Our Ref: 23/1230/TTCA
Your Ref: Jasmine Cottage 002

**South Cambridgeshire District Council
Application for Works to Trees in a Conservation Area**

Proposal: T1 Chinese Willow re-pollard to a finished height of 4 meters
T2 Beech Crown raise over outbuilding by 4 meters from ground level
T3 Prunus reduce crown by 1.5 meters and crown raise by 2.5 meters from ground level

Site address: 81 Green End Landbeach Cambridgeshire CB25 9FD

Jasmine Cottage, Green End, Landbeech, Cambridge

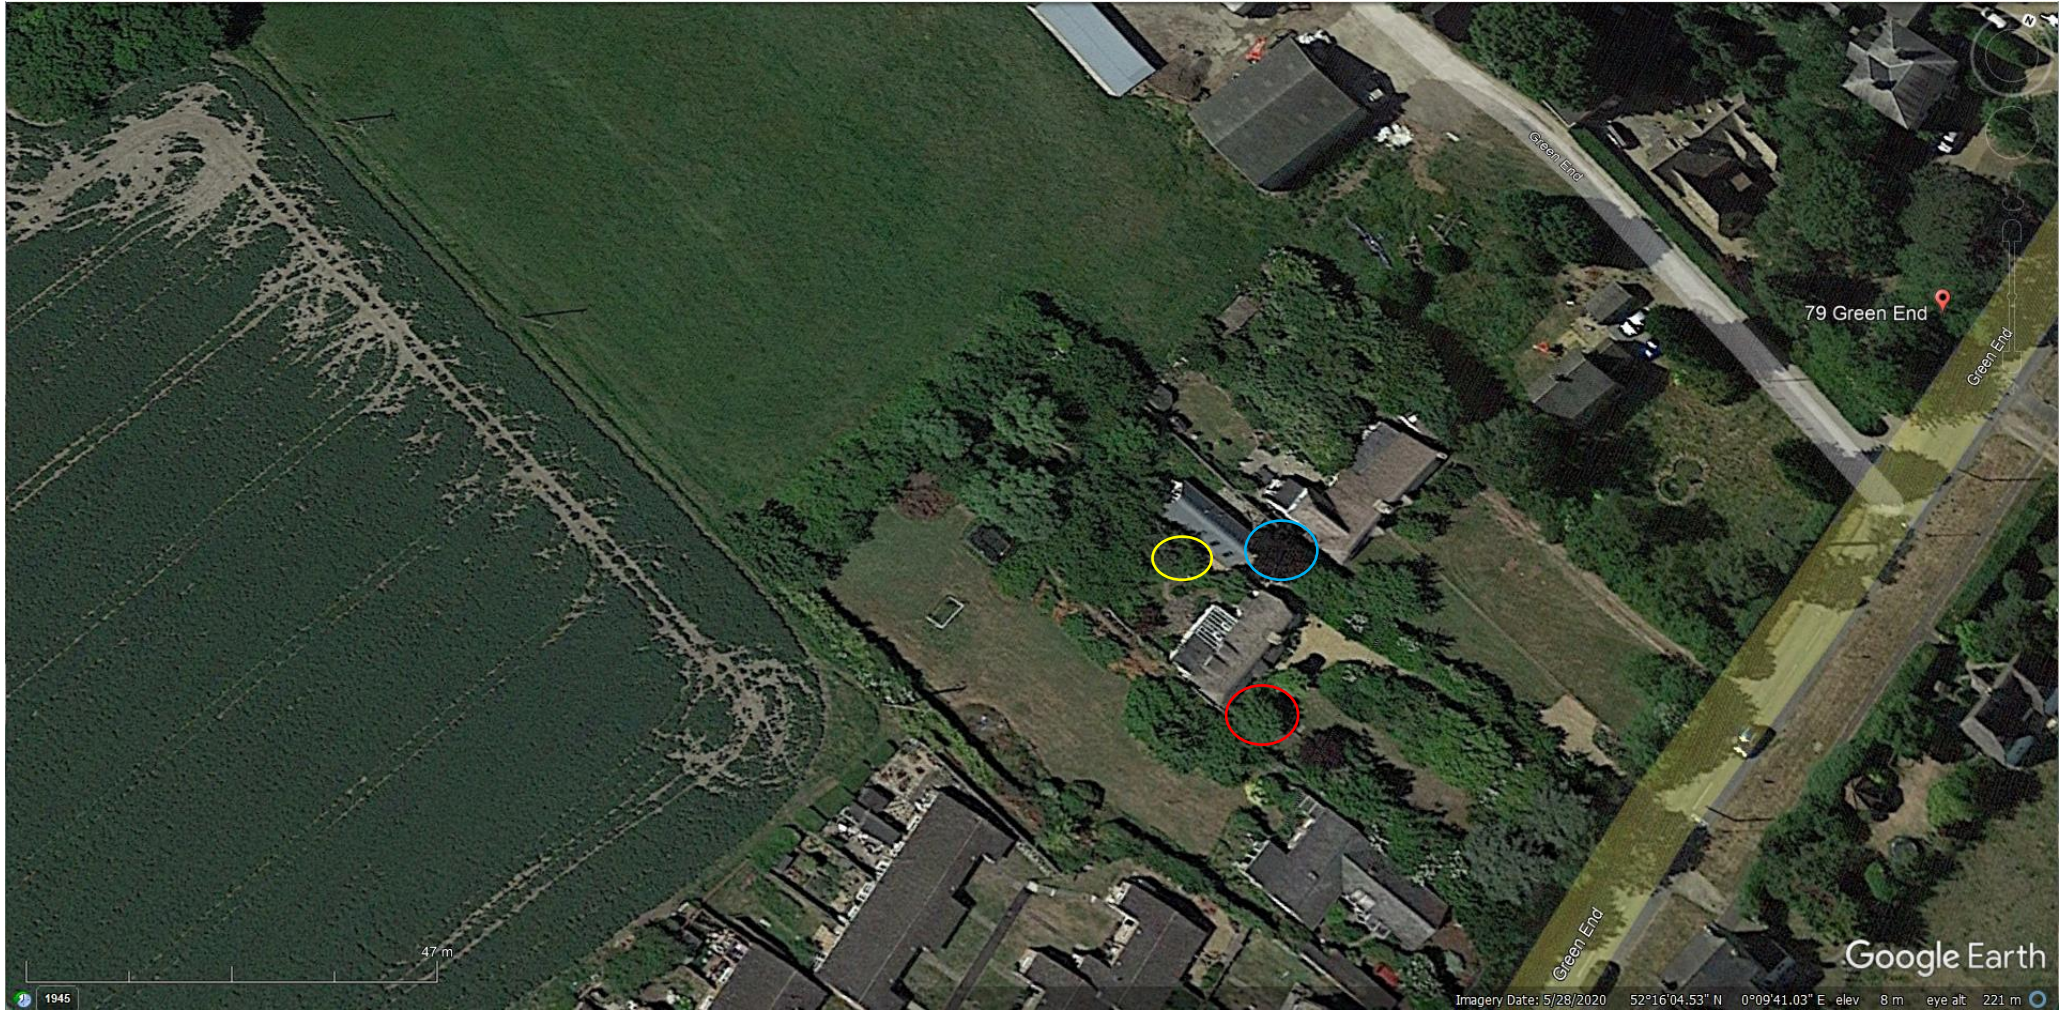
0. The address of the land where the tree stands does not appear to be correct or is not provided. Having cross checked your plan it appears that the trees shown are in the garden of 79 yet the proposal states location address as 81. Please clarify or supply a new plan.
